**Re: Residential Units
413 Harvard Dr. SE
Request Permanent C.O. - Accepted
Engineer's Stamp dated: 12-17-15 (K16D083)
Certification dated: 7-18-16**

**Re: 413 Harvard Dr. SE
Grading & Drainage Plan
Engineer's Stamp dated: 12-17-15 (K16D083)**

RE: 413 Harvard Drive SE (File: K16D083)
Grading and Drainage Plan
Engineer's Stamp Date – 10/19/15

A PROPOSED
GRADING AND DRAINAGE PLAN
FOR RESIDENTIAL UNITS AT
413 HARVARD DRIVE S.E.
ALBUQUERQUE, NEW MEXICO
OCTOBER, 2015

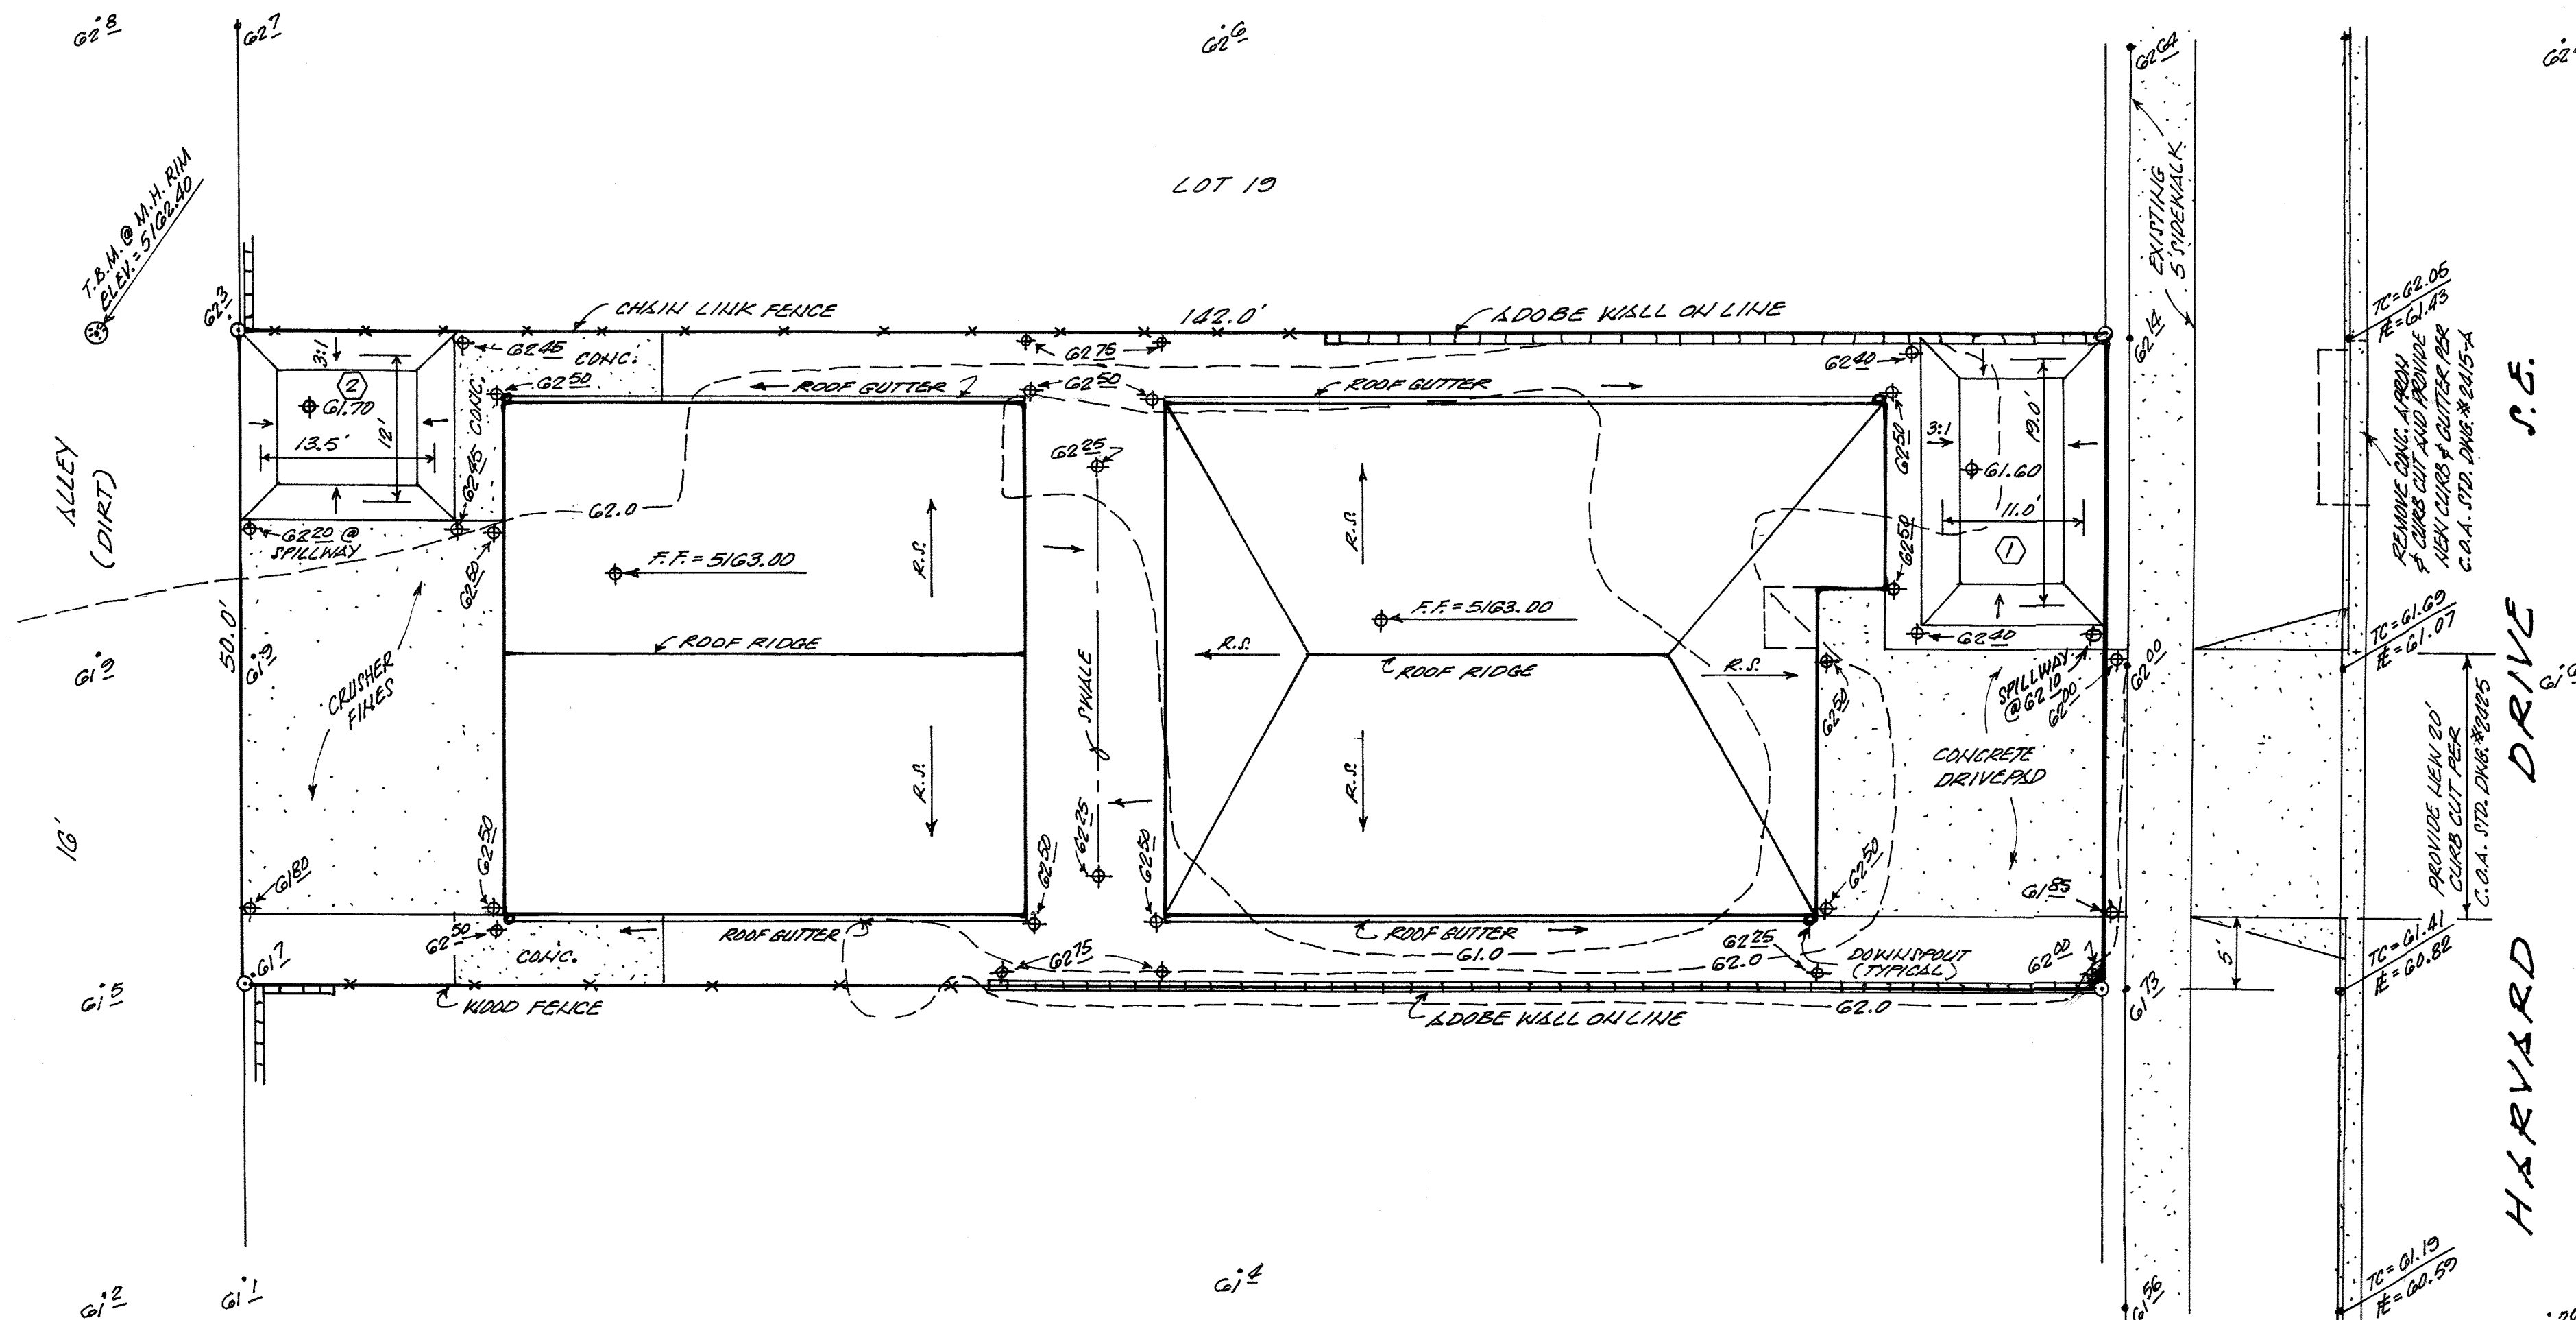
Based upon the information provided in your submittal received 10-19-15, the above referenced Grading Plan cannot be approved for Building Permit until the following comments are addressed.

- Provide offsite discharge flows to the alley west of the property and to Harvard Dr. east of the property. Drainage patterns for both the alley and Harvard Dr. appear to flow south. Ensure that offsite flows can be captured by downstream inlets and that no properties are adversely affected by discharged flows.
- Provide documentation allowing flows to enter alley west of the property.
- Provide adequate detailed information on the Grading Plan to ensuring no flows enter adjacent properties to the north and south.
- Show limits of concrete removal at the northeast property corner to accommodate First Flush Pond 1.
- Clearly identify and define property lines.
